Your Ref: OWPC16087
Our Ref: FG/162/17/PL 10-10-2017
Please ask for:
Mrs A Gardner

Demolition of existing detached garage & erection of 1 No. dwelling.
1 Upper West Drive Ferring

Thank you for your internet representation made on 1st November 2017 which has been recorded as '**an objection**' with the comments as follows:

PROPOSED GROUND FLOOR PLAN 1:100

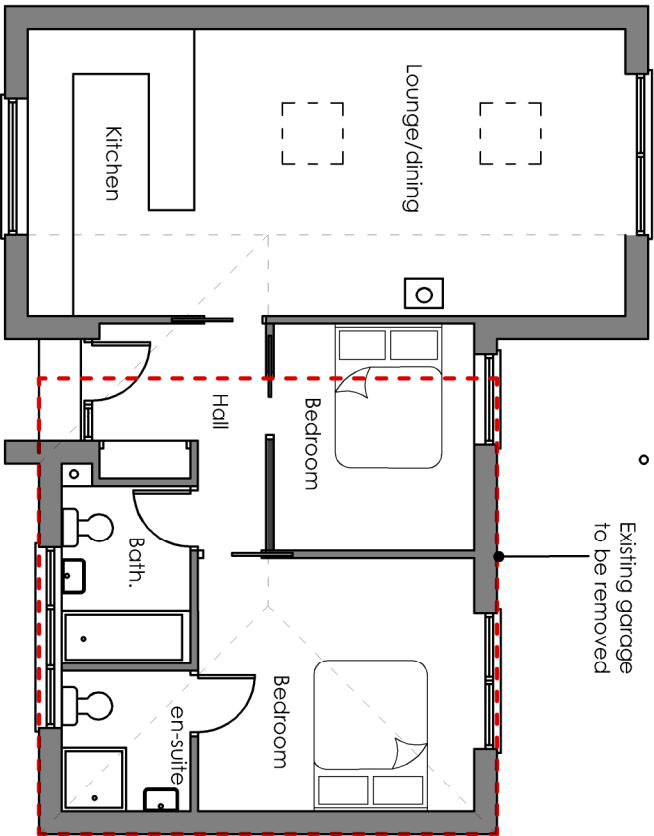
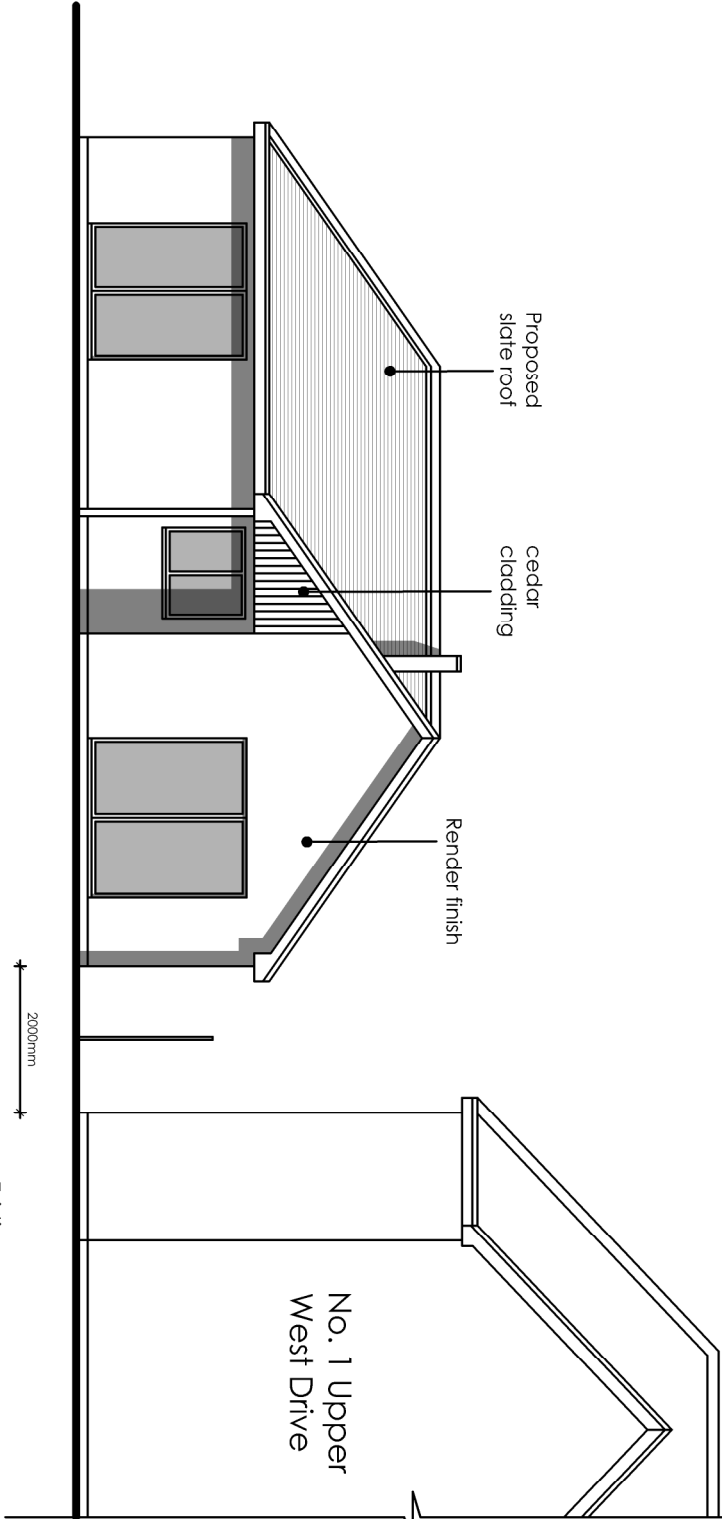
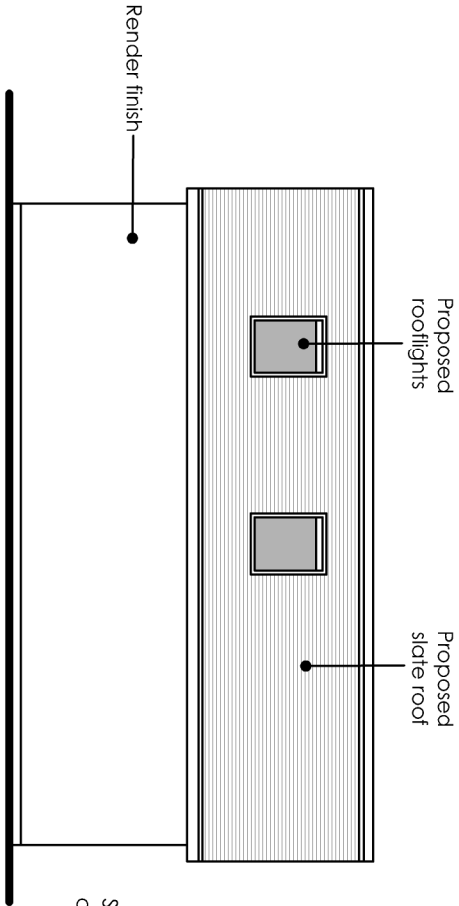
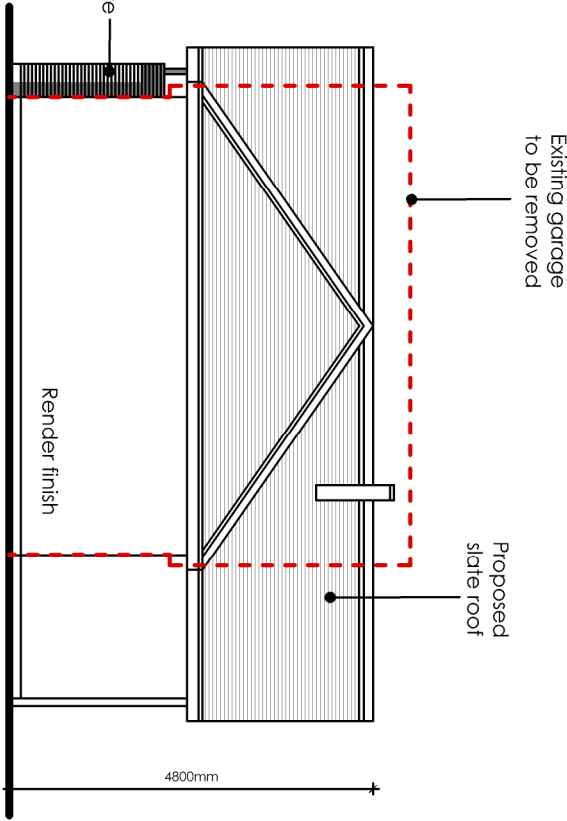
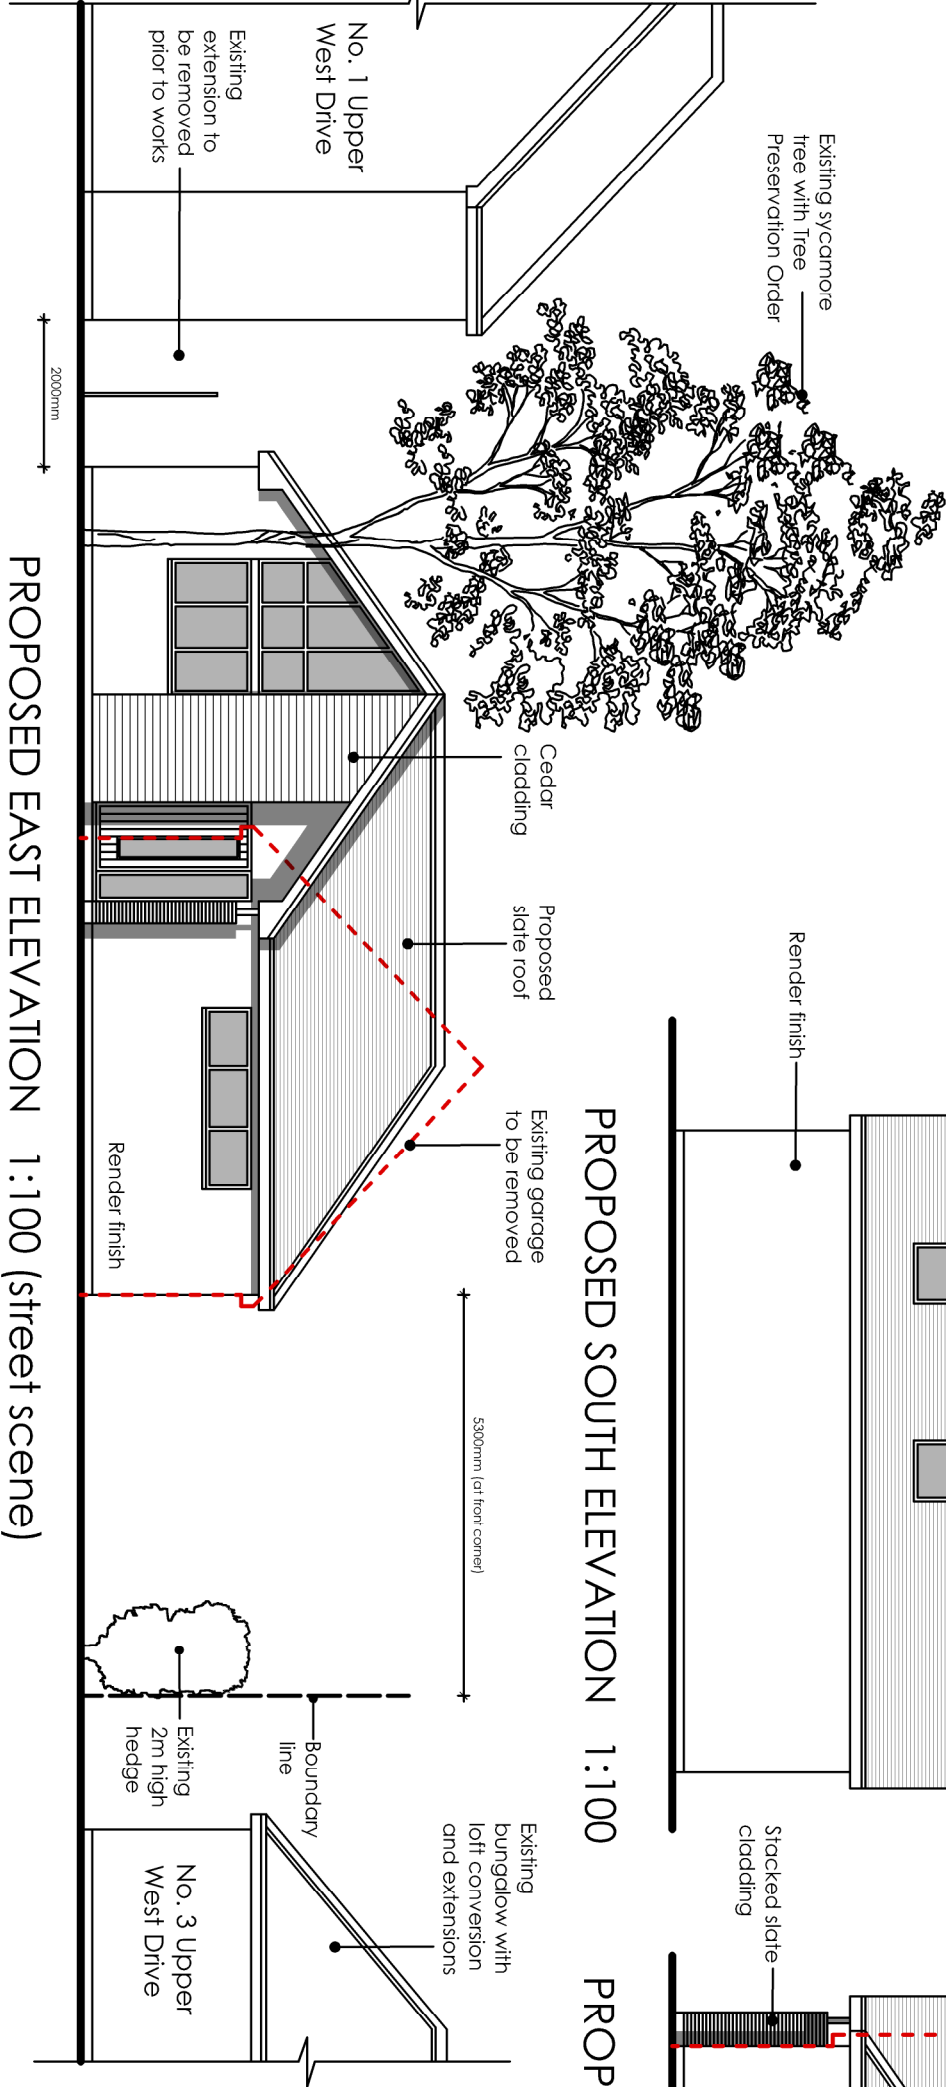
Even though this is a revised reduced plan from the proposed development in 3/17, this remains an over development of the site as garden infill, and is detrimental to the overall amenity of the area. There will be an increase in surface runoff, particularly with the additional drive way. This new driveway also involves the removal of a specimen horse chestnut that brings amenity to the area and should also possibly carry a TPO. There is potential impact on the Sycamore tree with the TPO due to it's size and proximity to the proposed bungalow. The site will be very cramped and out of keeping with the area.
